From: Stephen Harlow [REDACTED]
Sent: 13 November 2020 11:21
To: Planning <Planning@arun.gov.uk>; Andrew Wood <Andrew.Wood@arun.gov.uk>
Cc: nicola.harlow [REDACTED]
Subject: EP/124/20/HH

There will be a lot to get through with our observations and objections to planning application EP/124/20/HH (23 Upper Drive, East Preston) so there is no time like the present to make a start.

203075/ 06

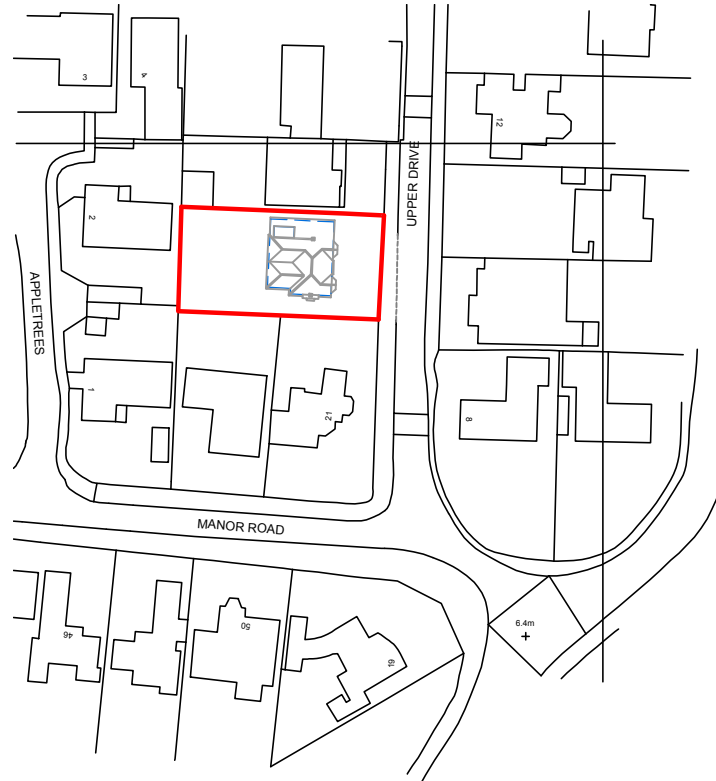
There is a proposal in the planning application to make changes to the verge in front of number 23. For information, the verge is owned by the Angmering-on-sea Estate Association. The proposal is to reduce the size of vehicle access from almost the whole frontage to a size that is not provided. From observation, you may guess at a figure.

- a) The answer provided on the application form is wrong.
- b) The intention to 'remove tarmac and reinstate grass verge' (203075/05B) is to be decided elsewhere and should not be included for consideration here.

203075/ 01

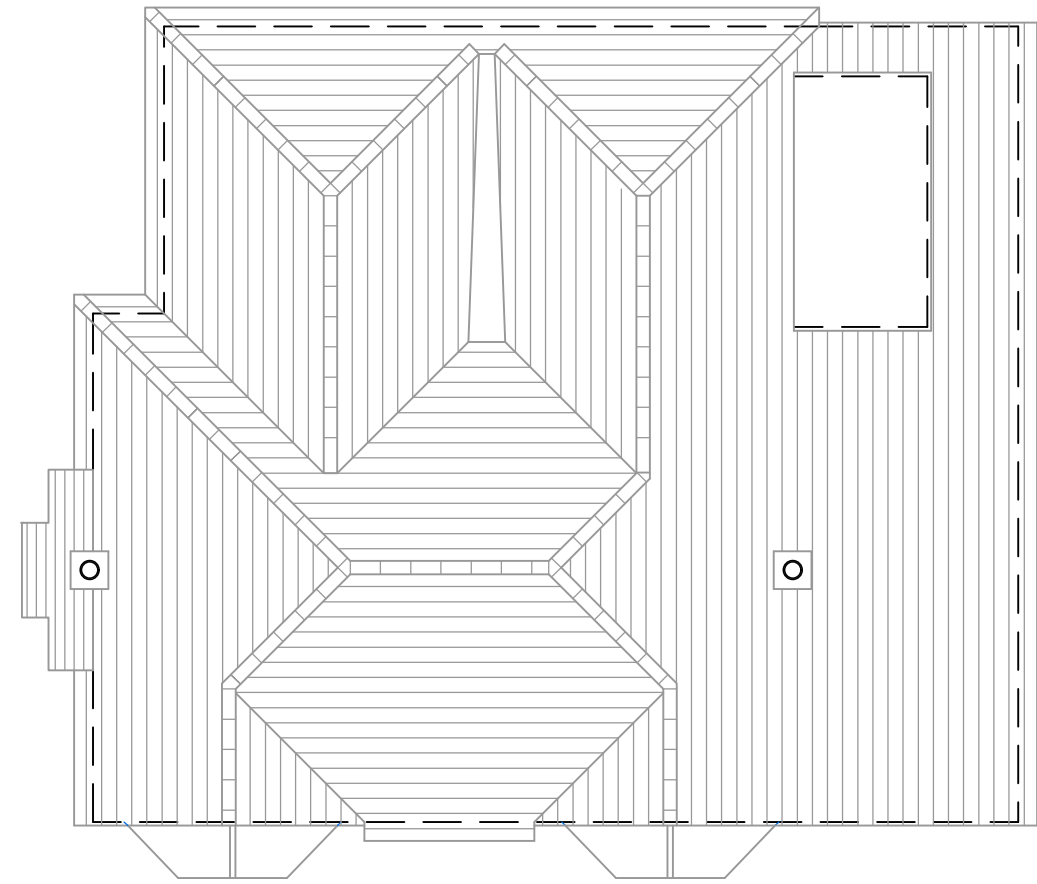
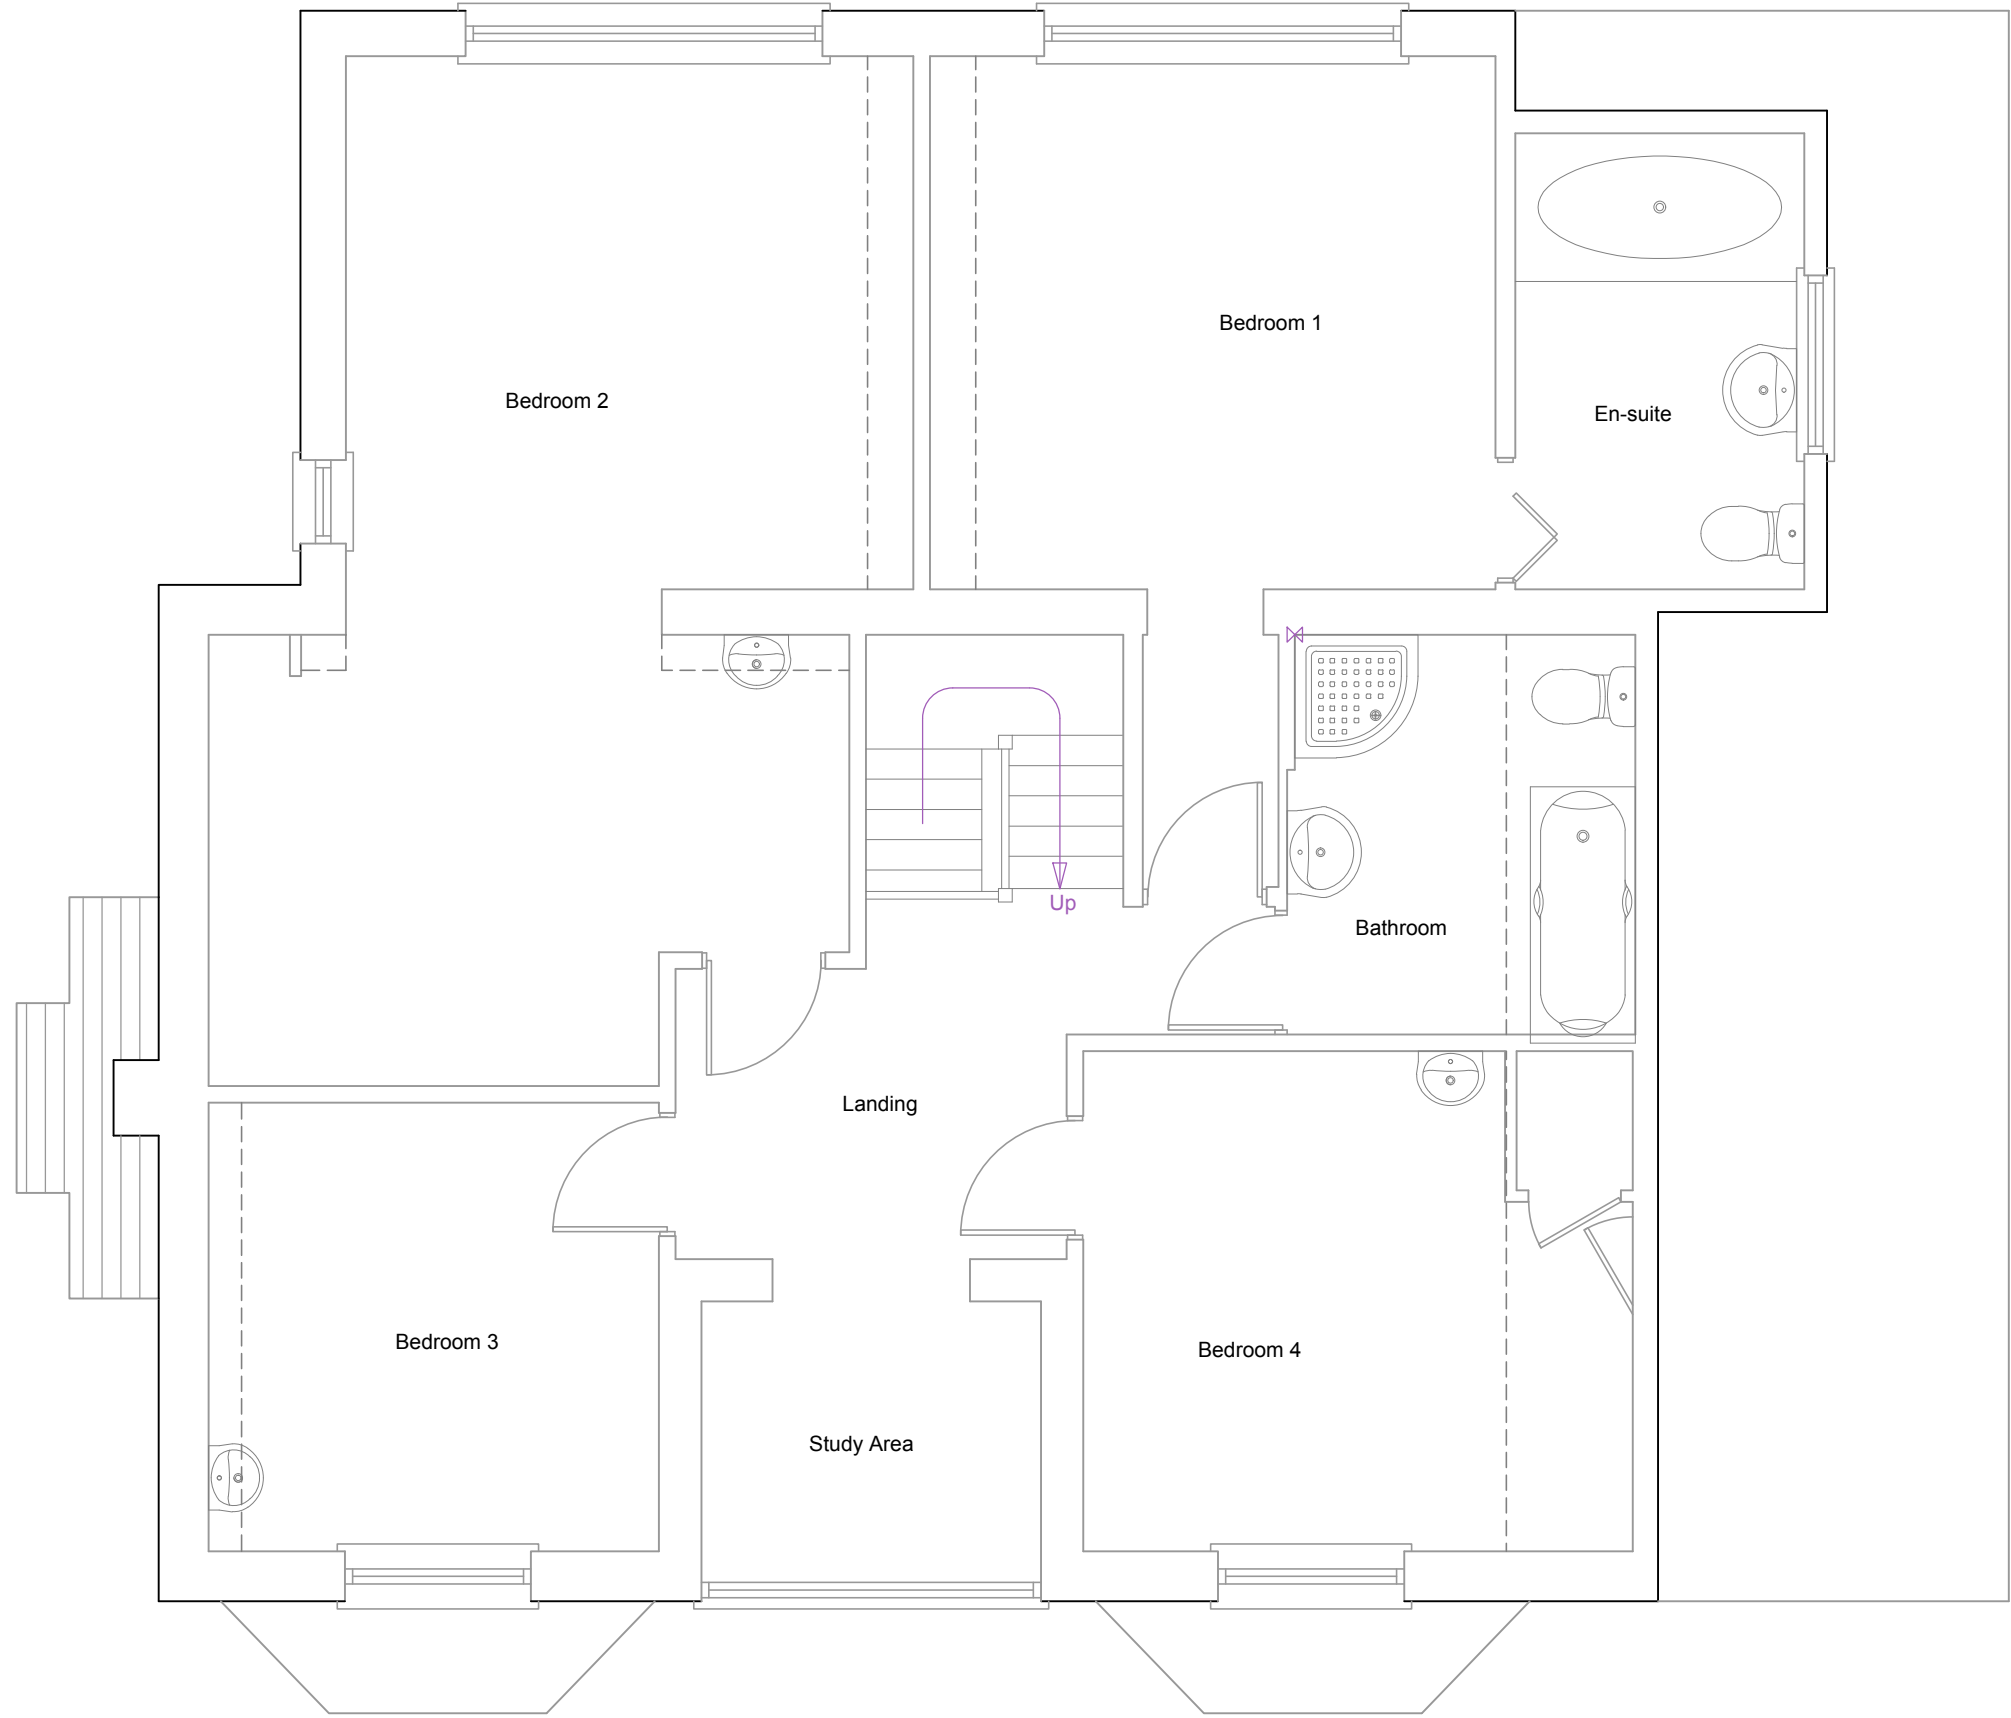
Point 4. Existing floor plans 203075/01

The ground floor plan contains a 'mistake' that gives the application the impression that there is currently no garage. The integral garage is labelled as a 'Dining Room'. This 'mistake' was also in planning application EP/96/20/HH and numerous objectors pointed this out. Someone even took a photograph and submitted it with their objection letter. The fact that the 'mistake' is retained in the latest application is a cause for concern.

203075/ 02

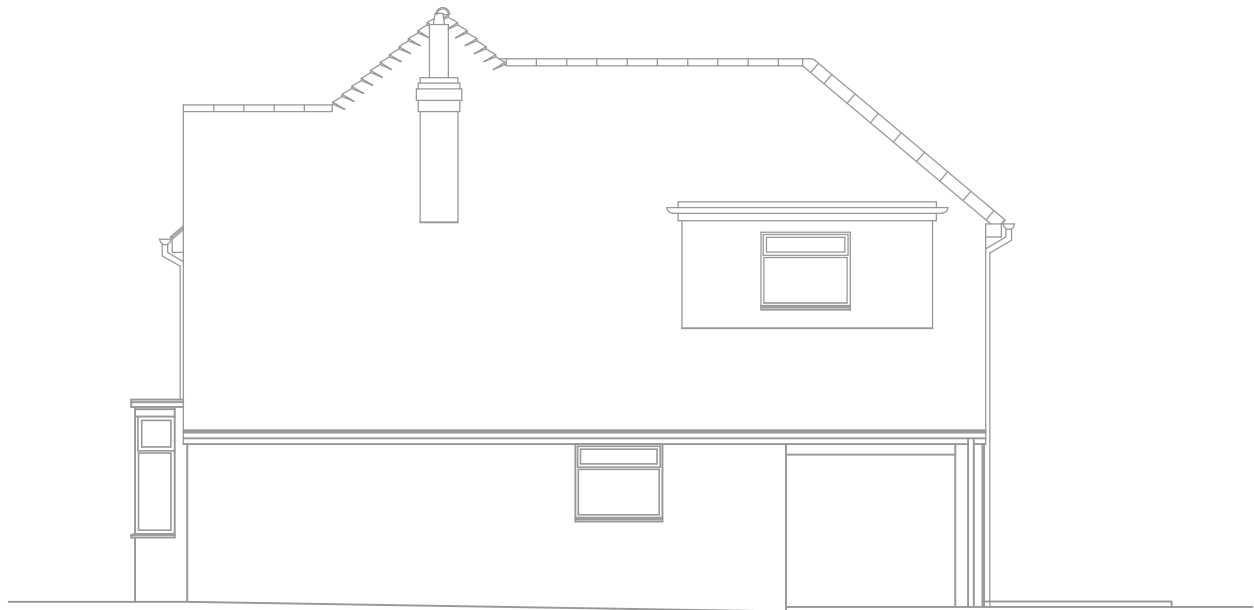
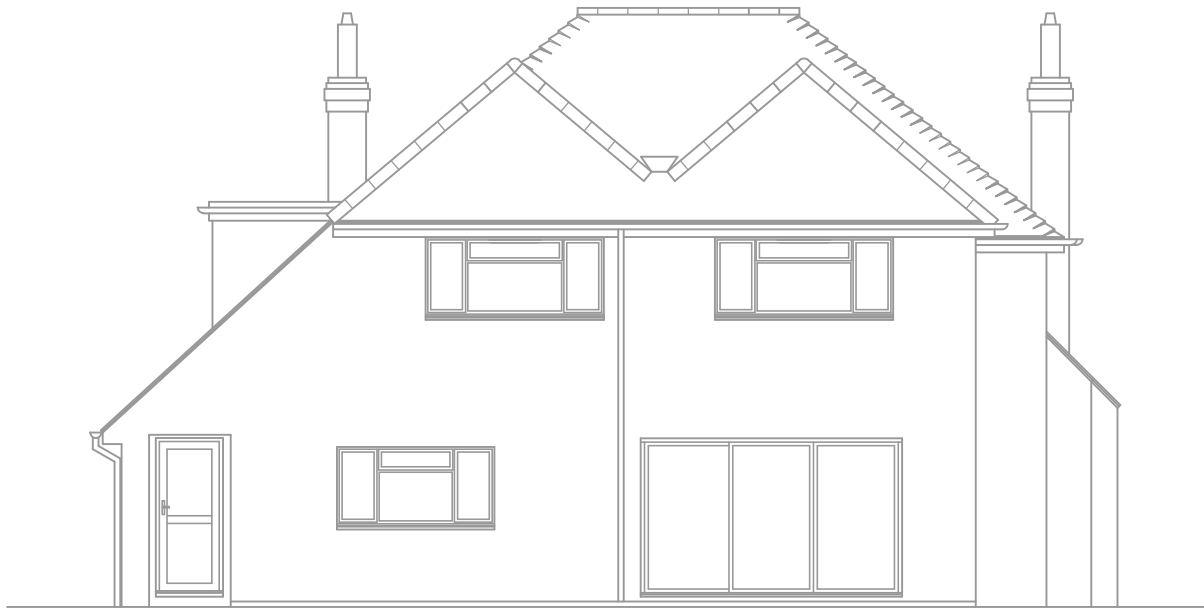
Since 203075/02 was prepared in July 20, the owners have had a new window created on the south side of the house on the ground floor. This window is not in the South Elevation drawing. The bottom central (most southerly) part of the chimney has been removed (visible in the East and West Elevations).

Drawing No Status Revision
203075/ 04 C

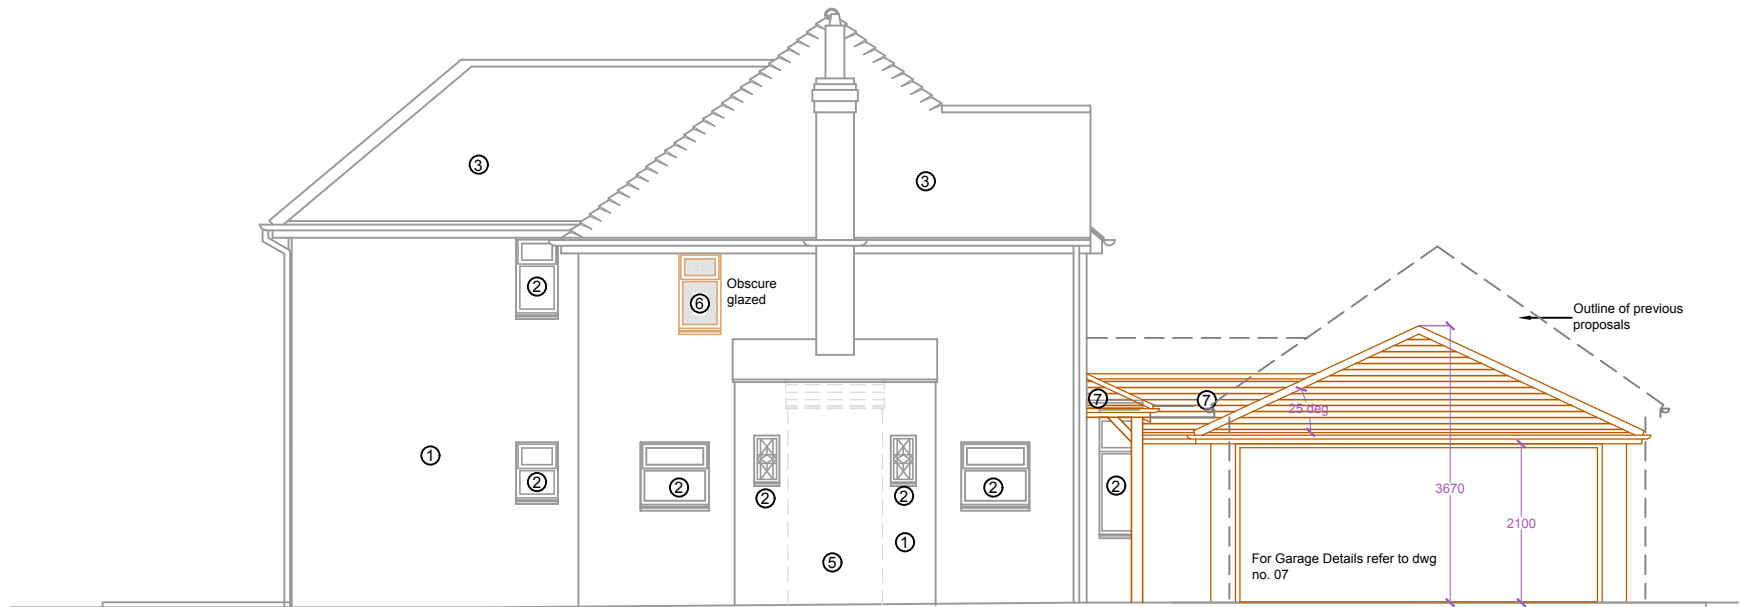
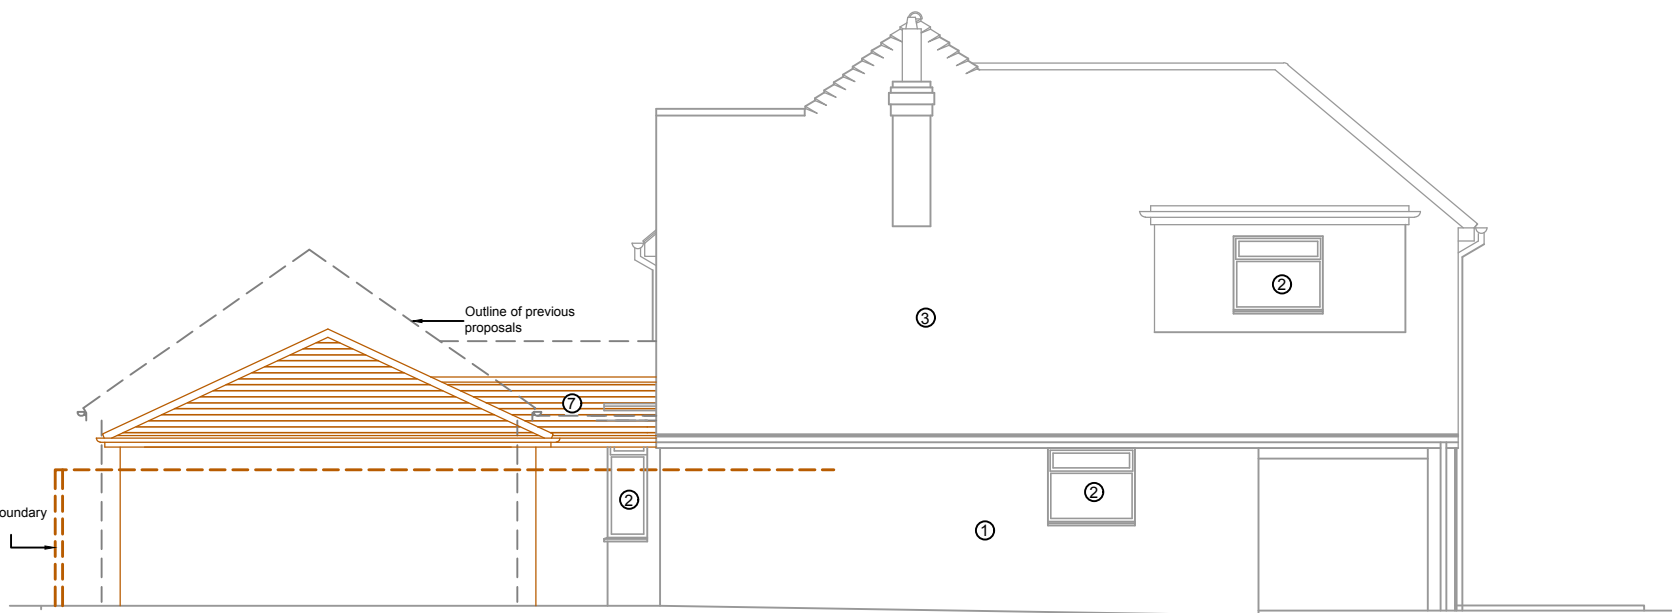
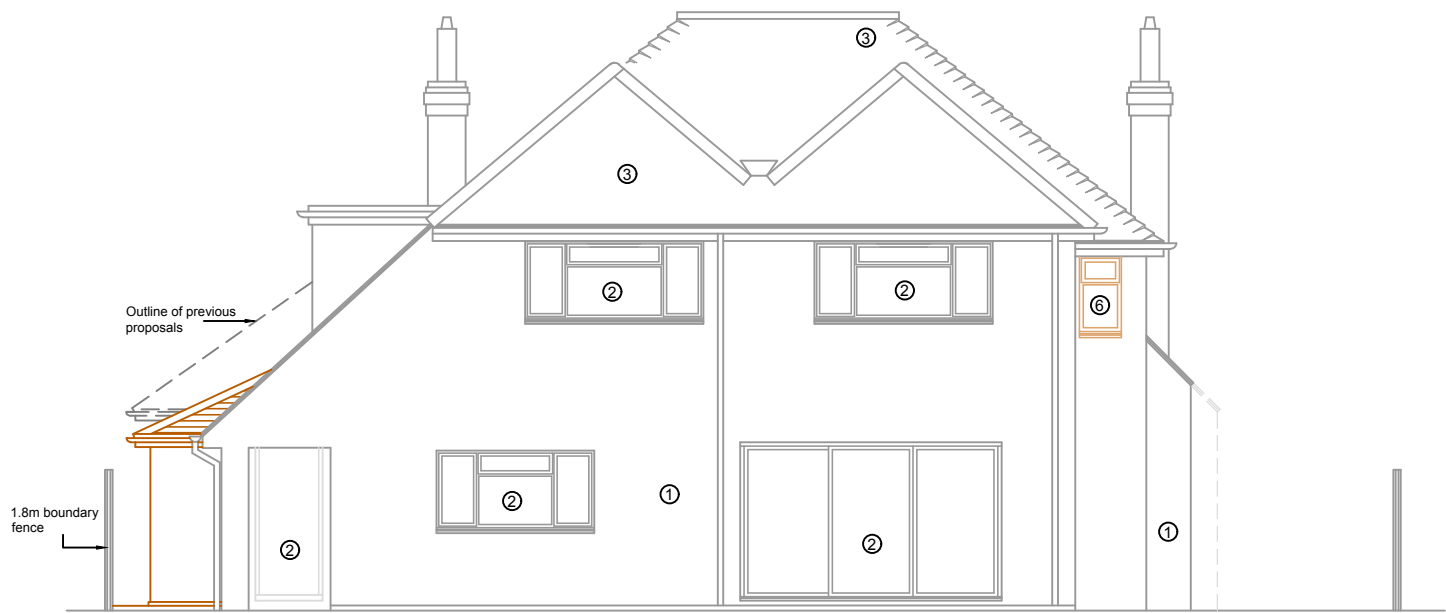
The new open aspect is pleasant and means that I do not need to reinstate a substantial fence as a vegetation control measure. The 'now absent' fence is shown in document 203075/04C.

This needs to be ignored in the planning process as it shows a screen that does not exist forward of the building line.

This window is, however, shown in 203075/04 and is identified as an existing window. This drawing is also dated July 20.

Document 203075/04 shows the modifications made to the chimney on the south side of the house. The current width of the chimney is shown in the East and West Elevation drawings.

An additional issue is that the North Elevation of document 203075/04 shows a 1.8 m high boundary fence in red dotted lines. Red is the colour on these drawings of new proposals. I have sole responsibility for that boundary fence, and I can assure you that there will not be a large fence erected there on the boundary. I would expect the plan to be amended before consideration of the application takes place because the inclusion is most misleading.

1. I object to the proposed first floor windows. The applicants remove the mature shrubbery screen on the southern boundary of their property and now propose to introduce a window that provides a fine view of the two reception rooms of number 59 Manor Road. Privacy is and should be protected.
